**From:**  
**Sent:** 15 February 2025 21:12  
**To:** DC Admin  
**Subject:** 2023-91280 Bromley Farm Quarry transport Vehicle & Wheel Washing

2023-91280 Bromley Farm Quarry transport Vehicle & Wheel Washing

### OBJECTION

ACCESS TRACKING

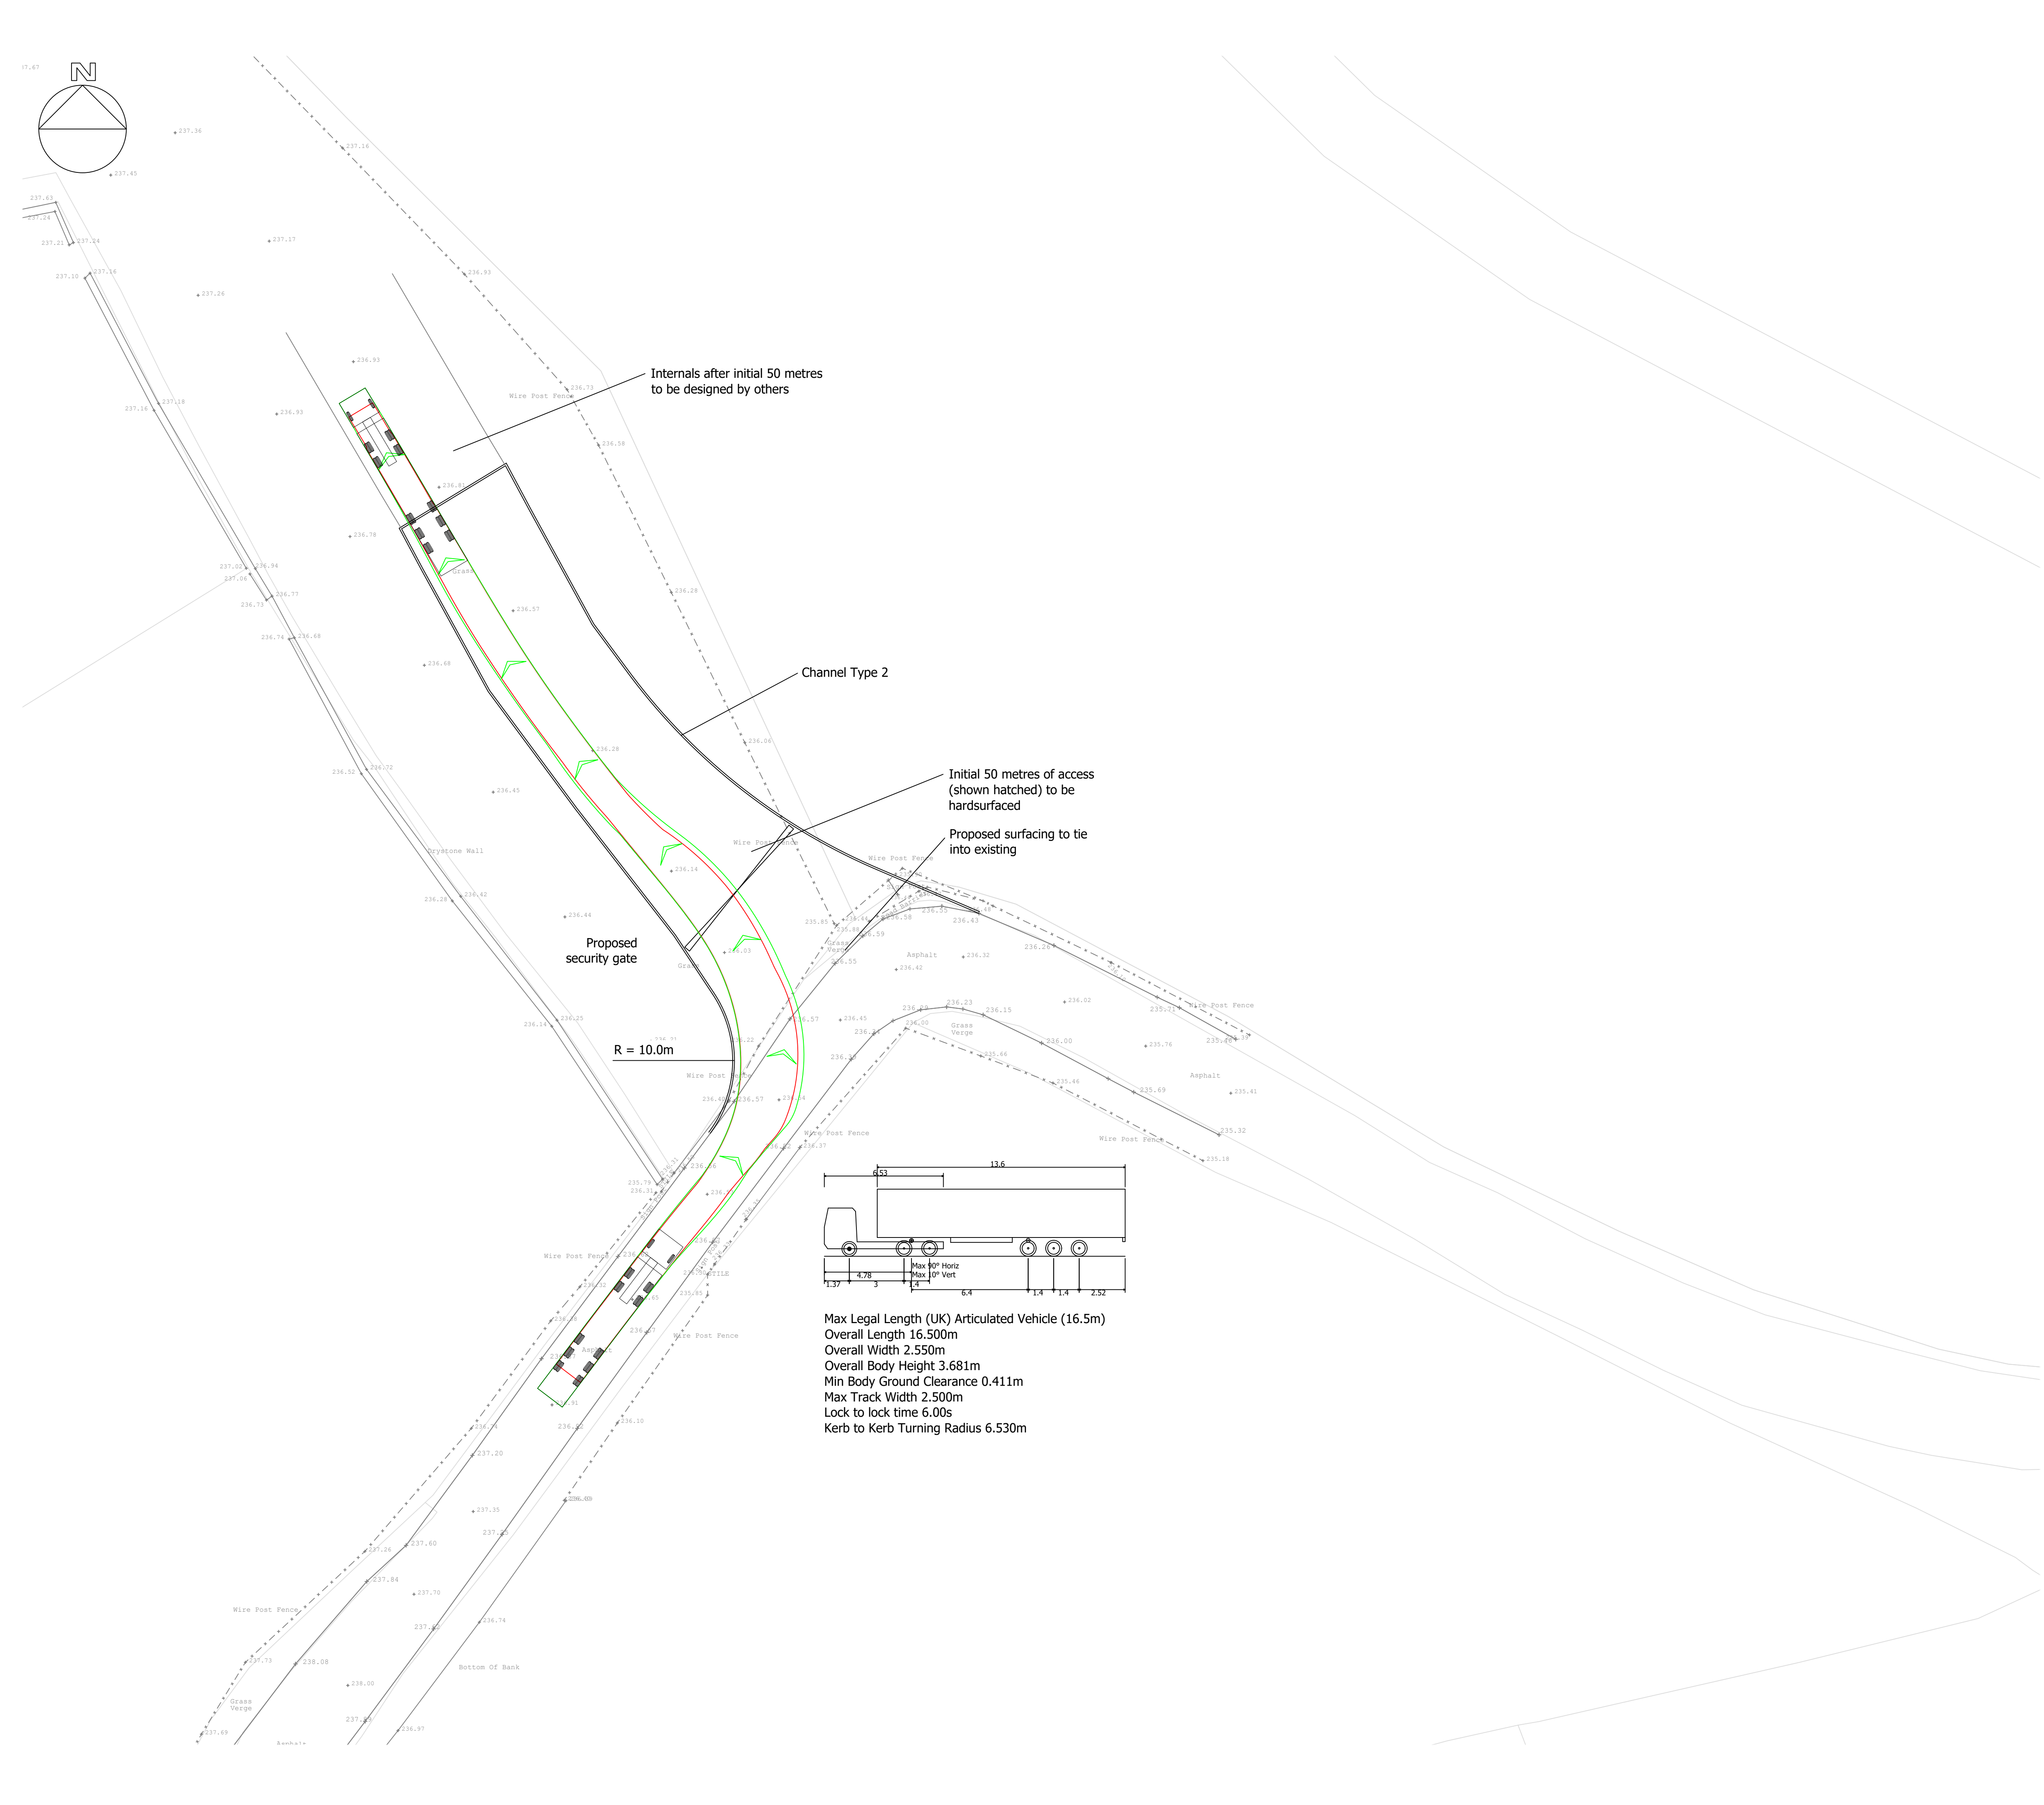
There is no details of the wheel washing

Objection : **a bath does not clean adequately for the highway**

A planning condition should be a full drive-through automatic washing for side/underbody, chassis Tyre and wheels system

The size of the auto-wash system should be specified to include all vehicles; including cars, leaving site

There is no Bund facility shown

There is no indication of additional water IBC's/tanks to supply the clean water

There is no system showing storage tanks how they clean / recover debris cleaned & any water used

There are no site lights shown so that drivers may inspect the vehicles are clean before entering the highway

There are no additional cross-drainage channels indicated on the sloping access road, so that water coming from the vehicles is channelled away into a soakaway and NOT directly onto the highway
